30 November 2020

2190947

Response to Further Agency and Organisation Submissions Powerhouse Parramatta – SSD 10416

## Powerhouse Parramatta

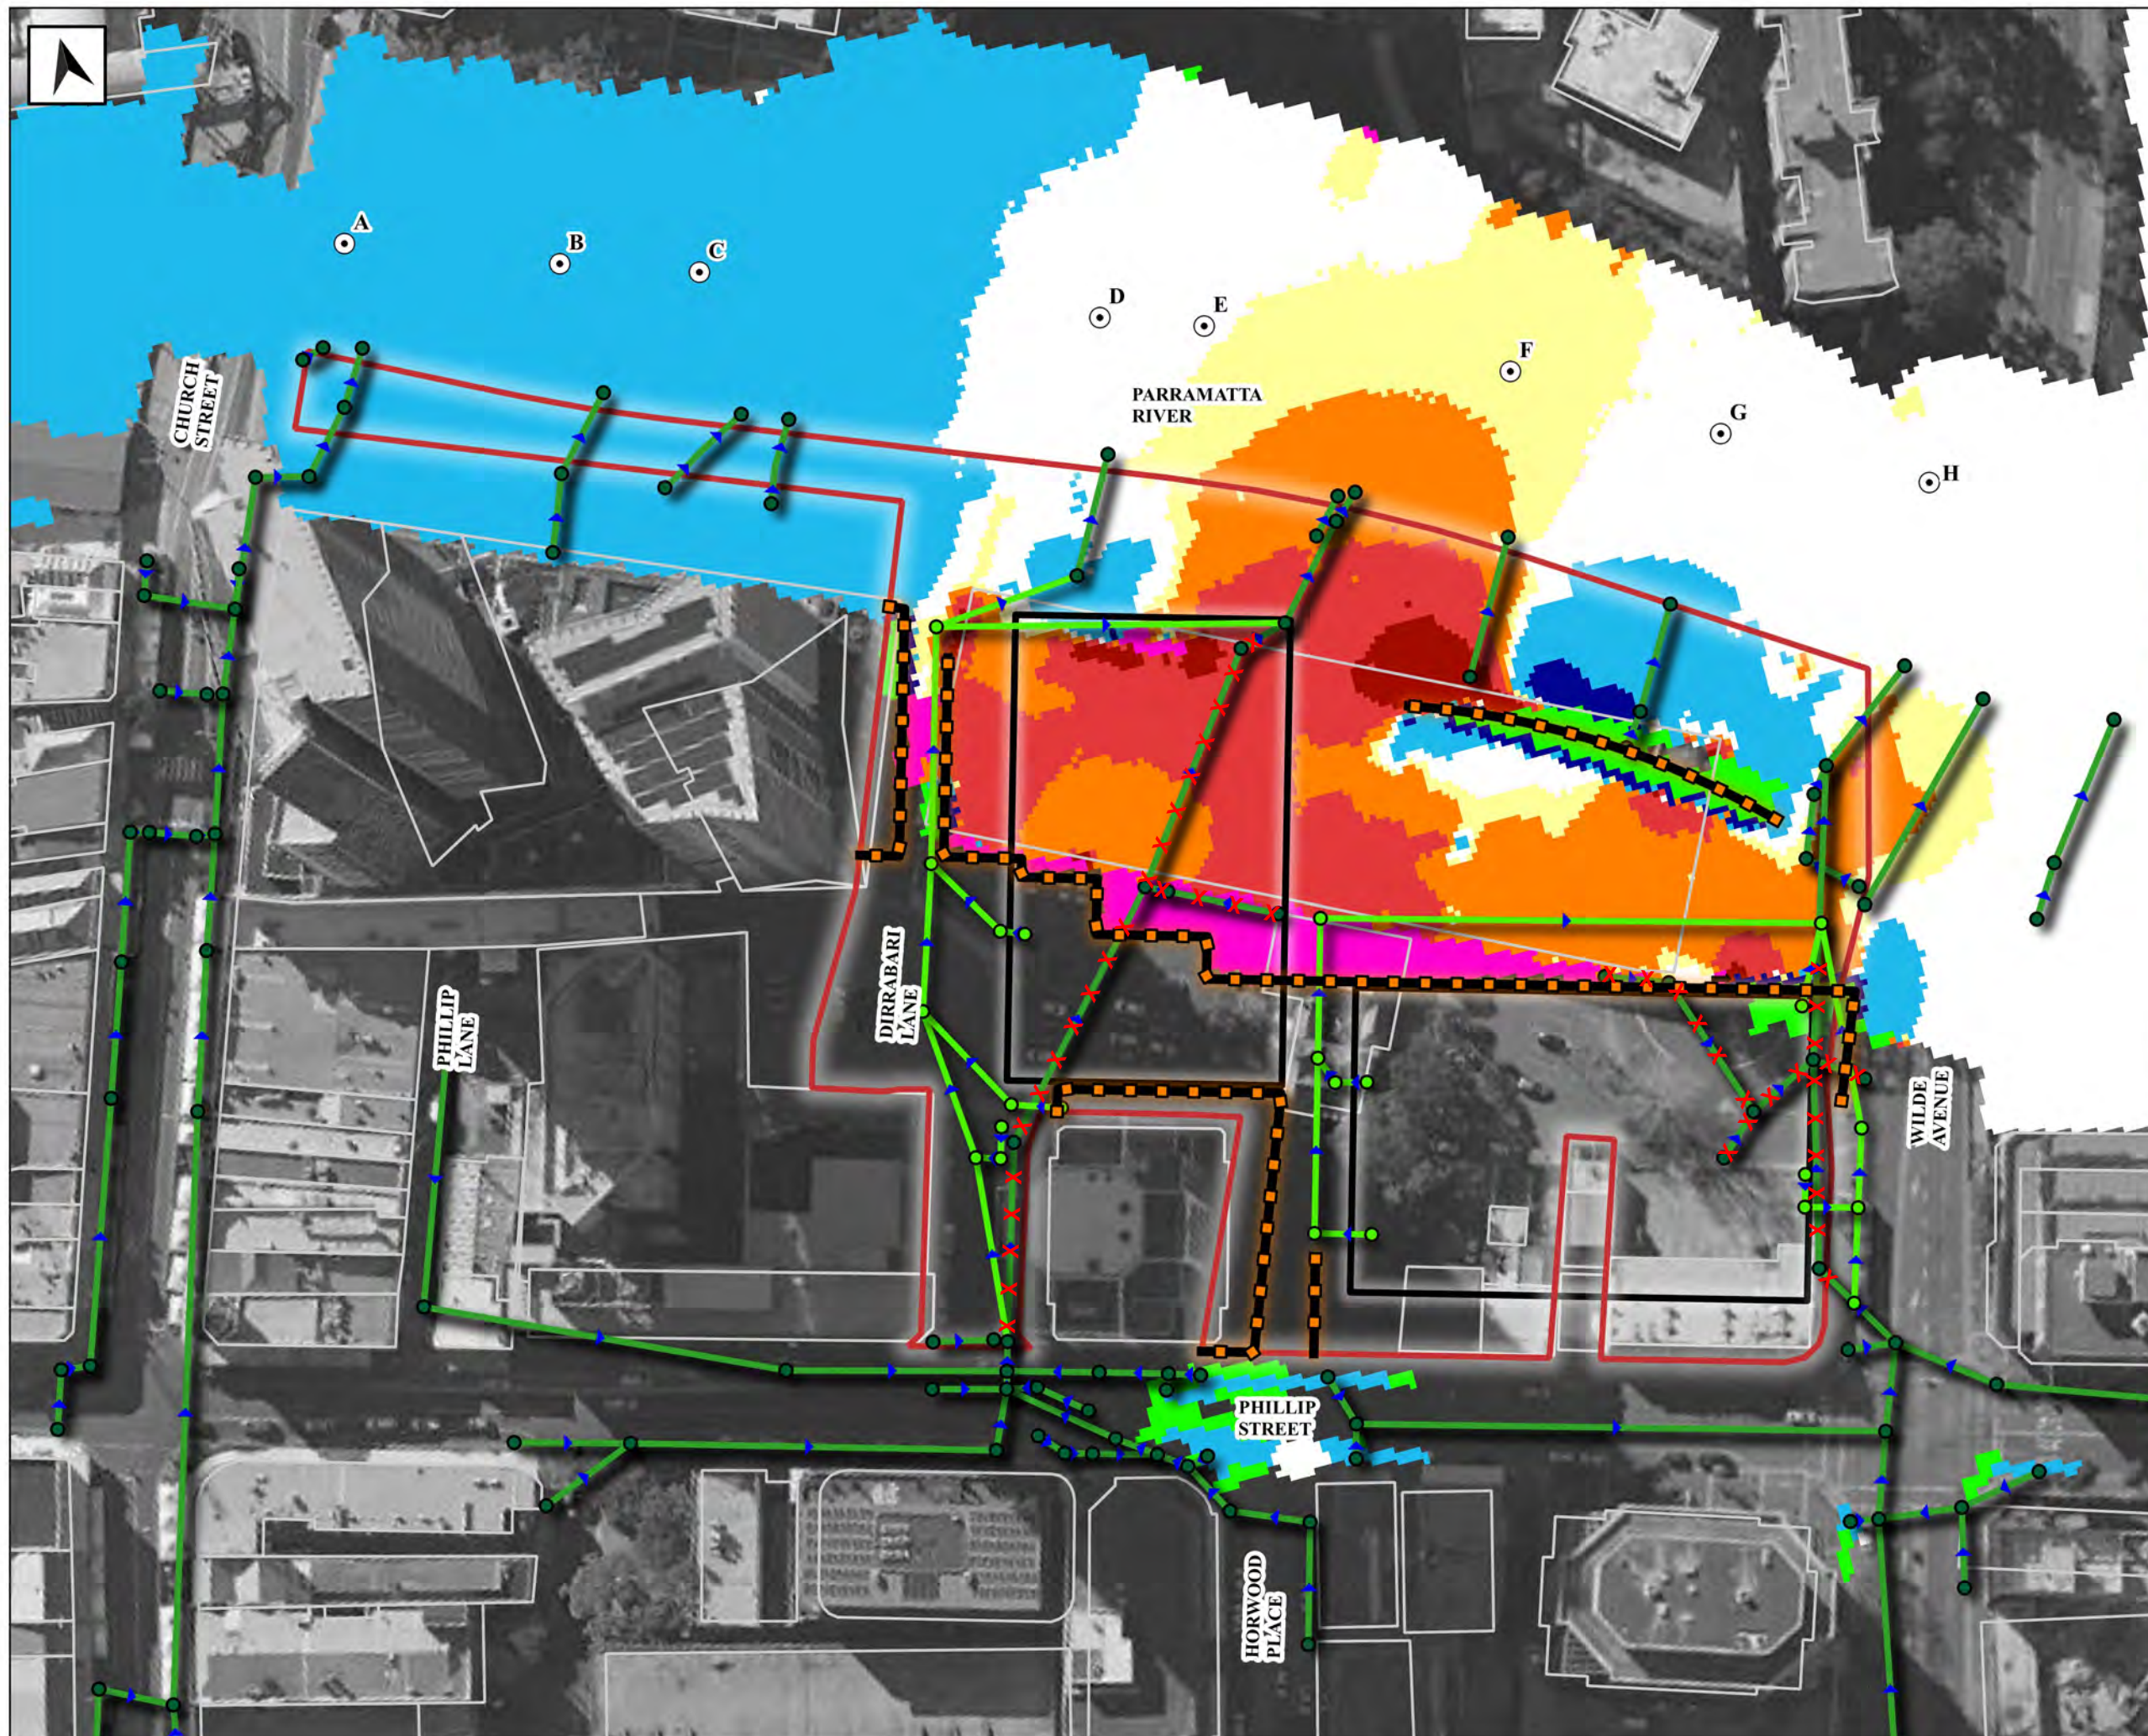
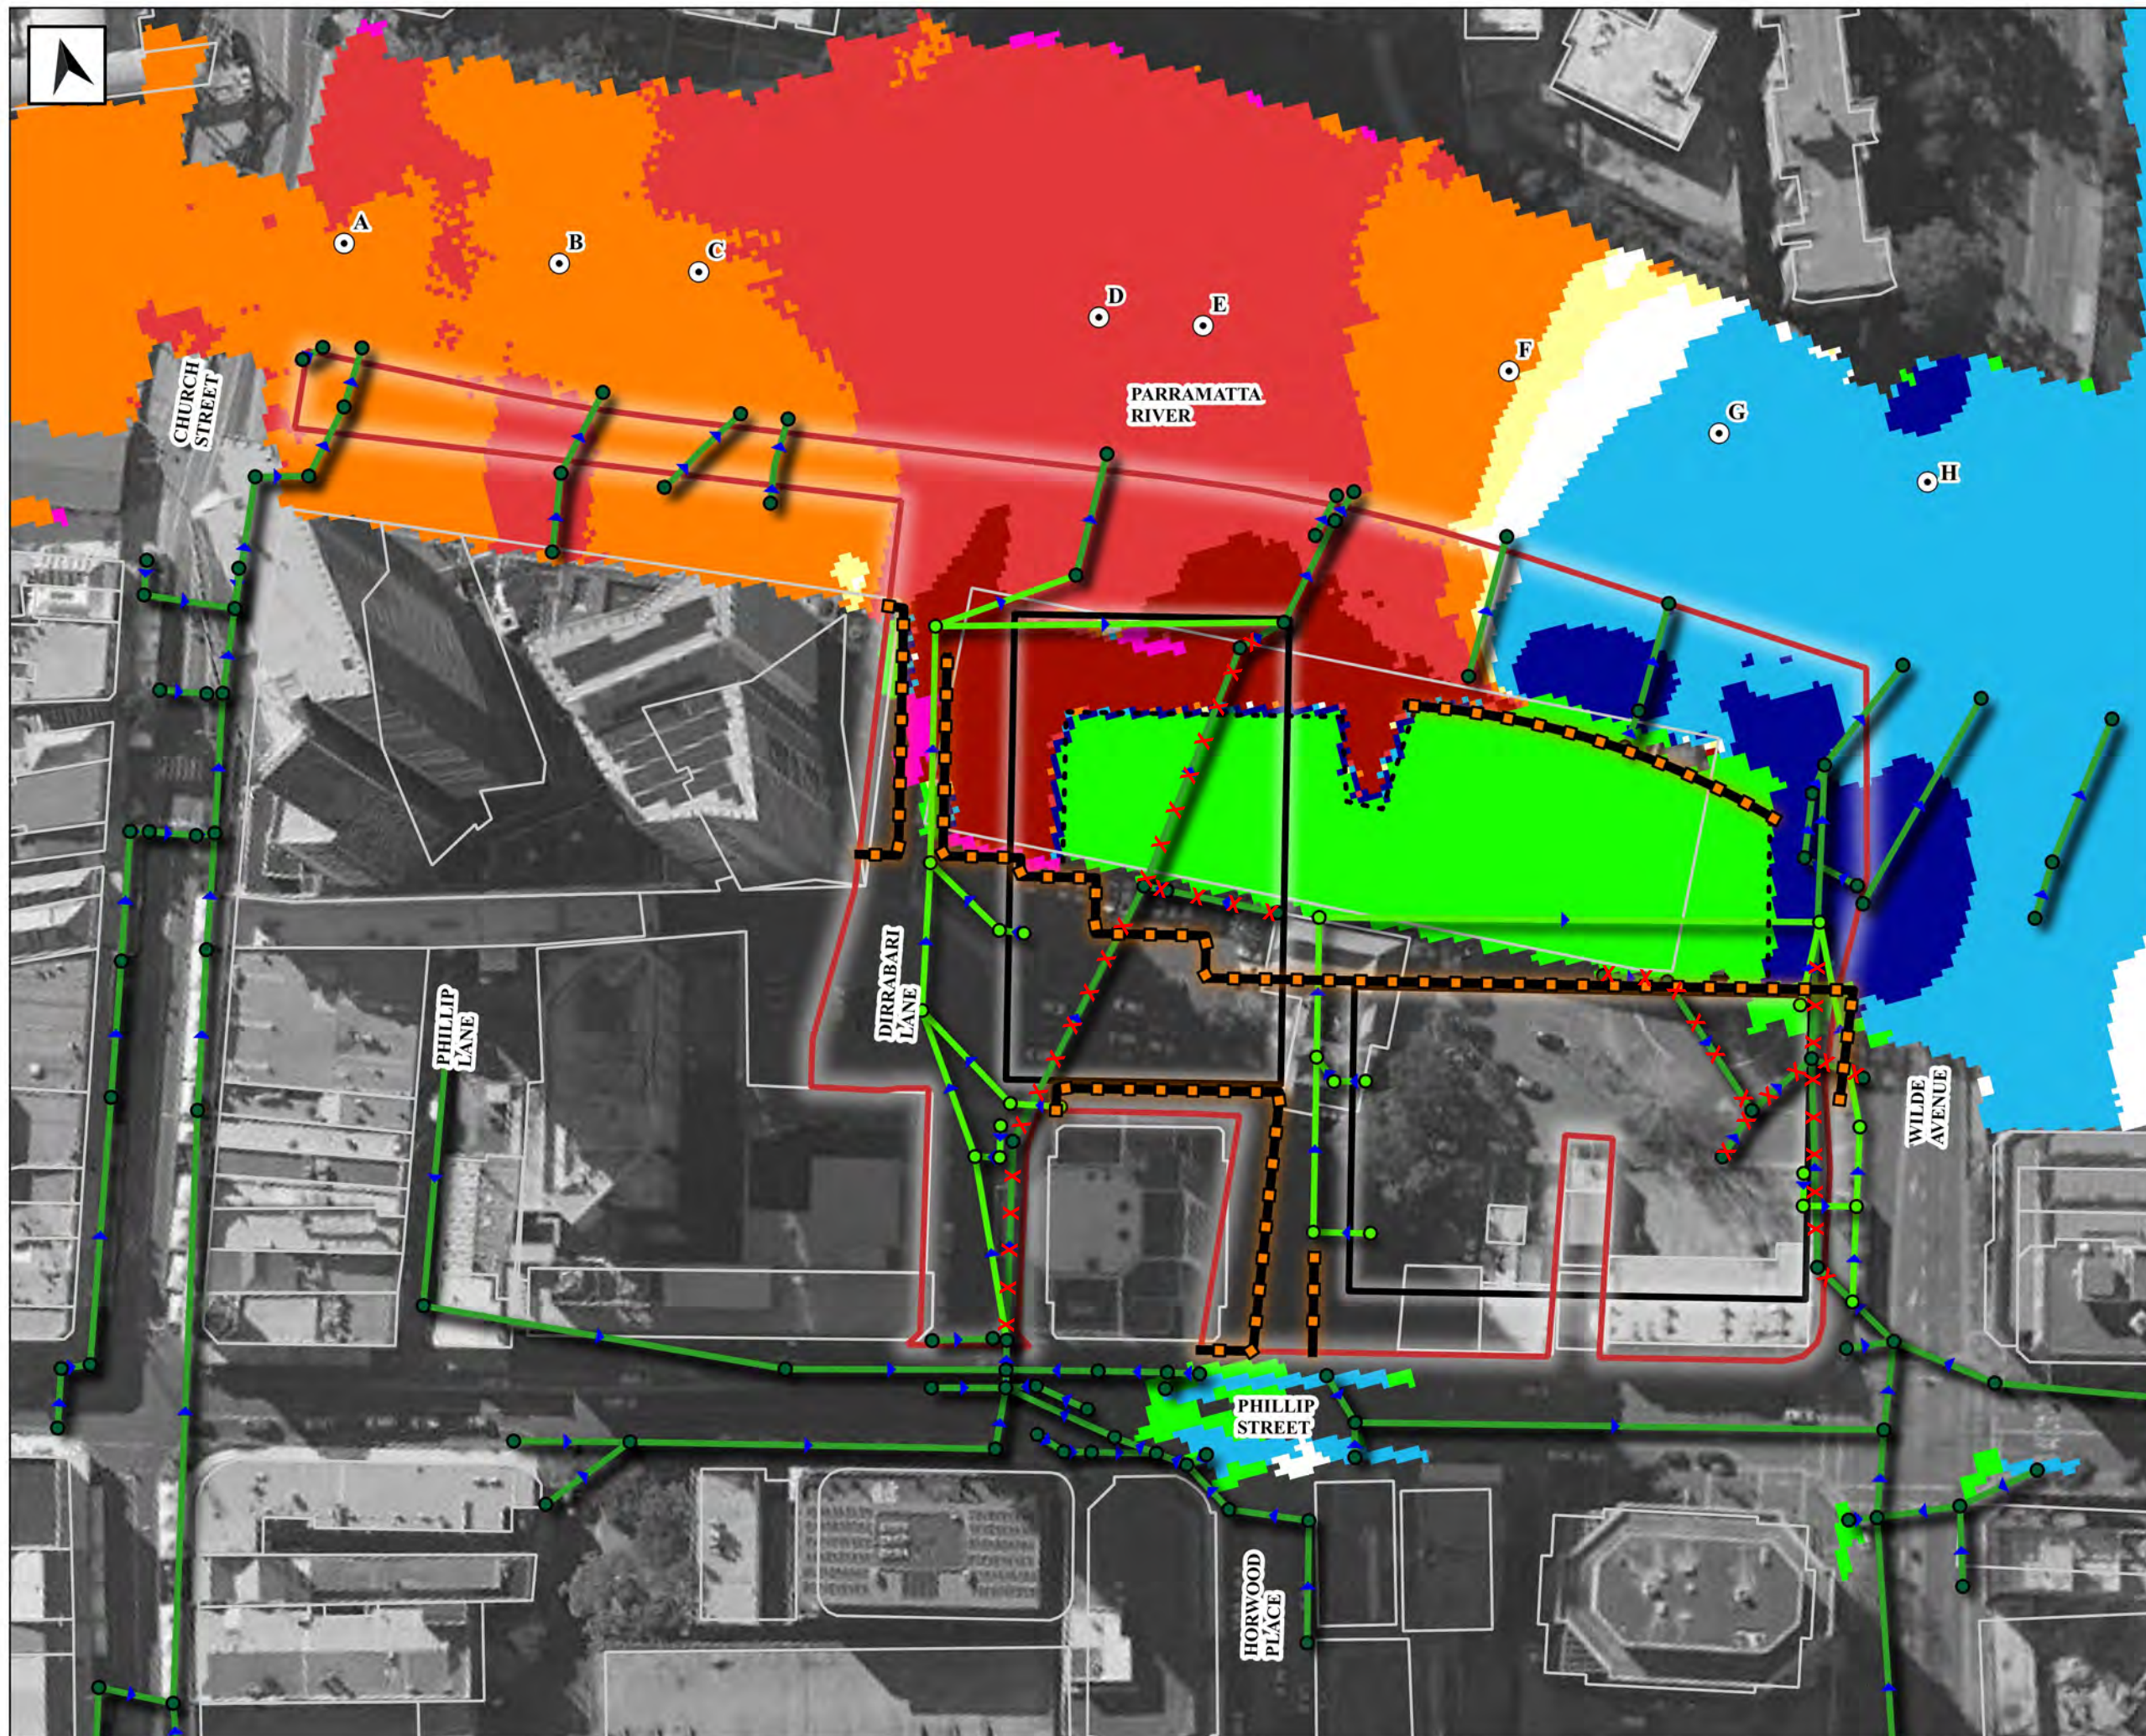
No.	Extract	Comment
CoP1	<p>Flooding and the Undercroft</p> <p>Council recognises the efforts made to modify the design to align with the Competition winning visualisation that showed a landscape solution that included a sloping embankment and a seamless relationship with the Parramatta River. Notwithstanding, the reality of the design is that the undercroft remains and the embankment serves to obscure it. The primary purpose of the undercroft is to convey floodwaters and at the same time provide additional habitable floor space for use by the Museum. Council maintains its view that the undercroft is not an appropriate solution for the site.</p> <p>In the Response to Submissions Report prepared by Ethos Urban on behalf of Infrastructure NSW dated 8 October 2020, it states that in response to concerns raised during the exhibition period, further detailed flood modelling was undertaken which confirmed that 'the proposed undercroft area is the best and only outcome for the site to mitigate and appropriately manage riverine flooding'. Council is contrary to this view.</p> <p>While Council acknowledges that the undercroft space will have limited access by the public through the erection of moveable screens managed by the Powerhouse, Council maintains its concerns regarding the suitability of the undercroft as a flood solution where the conveyance of floodwater through the undercroft also passes through proposed habitable floor space. This is due to the potential threat to life, property and critical building services in a flood event (including evacuation via a single, limited capacity lift, which provides critical access to mobility impaired). Council considers this to be in contradiction of the</p>	<p>As outlined in the Response to Submissions and accompanying Flood Risk and Stormwater Management Addendum Report, the Applicant maintains that there is no alternative to the inclusion of the undercroft whilst maintaining the architectural design of the museum. Adjustments have been made to the undercroft, in particular in relation to its use and management in response to Council's concerns, however, it is noted that contrary to this submission the undercroft is not considered to be habitable floor space. Flood modelling and advice confirms that the undercroft is a suitable flooding response.</p> <p>The Applicant maintains that the design and operation of the undercroft as well as the broader Powerhouse Parramatta proposal remains appropriate and safe from a flooding perspective. The concerns identified in Council's submission have been previously addressed in detail in the Response to Submissions and accompanying Flood Risk and Stormwater Management Addendum Report, and the responses in these documents should be referred to.</p>

No.	Extract	Comment
	<p>Floodplain Development Manual and NSW Flood Policy. This space will have a level floor and the 1% AEP (100 year) floodwaters will flow with substantial velocity 2-3m deep extending to the back wall of this structure.</p> <p>It is Council's view that there are alternative solutions, including a design that delivers an alternative means of achieving floodwater conveyance along the river through an appropriately designed landscaped riverbank. There are other reaches of the river nearby with similar river flow, river width and which have cross sections that contain this 1% (100 year) flow within the boundaries. These typically have sloping banks that enable people to safely find their way to higher ground out of the river corridor as floodwaters rise.</p> <p>In this regard, Council reiterates its earlier recommendation that the undercroft be removed from the design. It also recommends the undercroft be replaced with a suitable sloping riverbank section that may be a viable solution to manage the conveyance of floodwater. This would also have the added benefit of creating a more integrated foreshore landscape interface where the 'natural' sloping riverbank profiles that existed before the existing car park was originally constructed (and which appear to be still visible on site) could be considered as the baseline for predevelopment conveyance capacity and afflux considerations.</p> <p>In relation to overland flow, once riverine flooding and conveyance has been resolved safely - by changing the built form and surrounding landform, it will also be necessary to re-examine the overland flow pathways across the site and how these affect useability, public safety and risk management.</p>

AU3	<p>Following review of the RTS, Australian Unity remain concerned regarding the overland flooding considerations.</p> <p>The existing 600mm diameter pipe which currently runs under Dirribarri Lane and the multideck carpark will be replaced by a 1200mm diameter pipe running under Dirribarri Lane and heading directly north to the river. On the eastern side</p>	<p>It is noted that the advice provided by Molino Stewart is not made in relation to the documentation provided with the Response to Submissions. The matters raised within this submission are adequately dealt with in Appendix J of the Response to Submissions Report.</p>

No.	Extract	Comment
	<p>of the subject site a new 600mm pipe will be laid to take water directly to the river between the two museum buildings.</p> <p>Molino Stewart have raised concerns with the flood modelling prepared by Arup at Appendix O of the EIS. In particular, concerns are raised in relation to whether adequate consideration has been given to the potential blockage of stormwater pits. Blockage in stormwater pits has the potential to change the reported flood modelling results.</p> <p>It is noted that City of Parramatta Council requires an assumption of a 100% blockage factor for any flood modelling associated with development applications in the CBD. This assumed blockage percentage will have a significant bearing on whether the proposed development will increase or decrease flood levels at the subject site.</p> <p>The existing stormwater flows pond in front of the subject site and flow in a 600mm diameter pipe under the Dirrabirri Lane to the river. When the flows to the low point exceed the capacity of the pipe the water rises until it reaches the high point in Dirrabirri Lane and the high point in Willow Grove and flows overland around the subject site.</p> <p>If the inlet to the 600mm diameter pipe is partially blocked, less water will get into the pipe and more water will have to flow overland to the river in the same storm event. This means that any blockage in the pipe will increase the depth of the flows around the subject site and the depth of ponding in front of the building. A 100% blockage will mean all the flows go overland and maximise the flood depths at the subject site.</p> <p>The overland flow management strategy for the PPM is to increase the capacity of the pipe in Dirrabirri Lane and to provide a new pipe to take overland flows along the eastern side of the subject site. This will effectively increase the flow rate underground and reduce the flow rate overland. Molino Stewart are concerned that if the inlets to the pipes are 100% blocked then they will make no contribution to flood conveyance and will not reduce flood levels at the subject site. As it is proposed to increase the ground levels to the east of the subject site and if Dirrabirri Lane is increased in level, then overland flow water will need to pond to a higher level in Phillip Street and increase the flood levels for the subject site.</p> <p>Requested Actions:</p> <p>3a) Australia Unity support the provision of amplified stormwater pipes on either side of 32 Phillip Street site.</p> <p>3b) The flood impacts of the final PPM design should be tested using City of Parramatta Council's more up to date, and peer reviewed, flood model when it becomes available to ensure that there will be no adverse flood impacts on the subject site or the surrounding public domain.</p>

No.	Extract	Comment
	<p>3c) The PPM project team should be requested to provide updated flood modelling accounting for an appropriate blockage percentage for stormwater pits.</p> <p>3d) The civil design solution must not increase flood levels adjacent to 32 Phillip Street.</p>
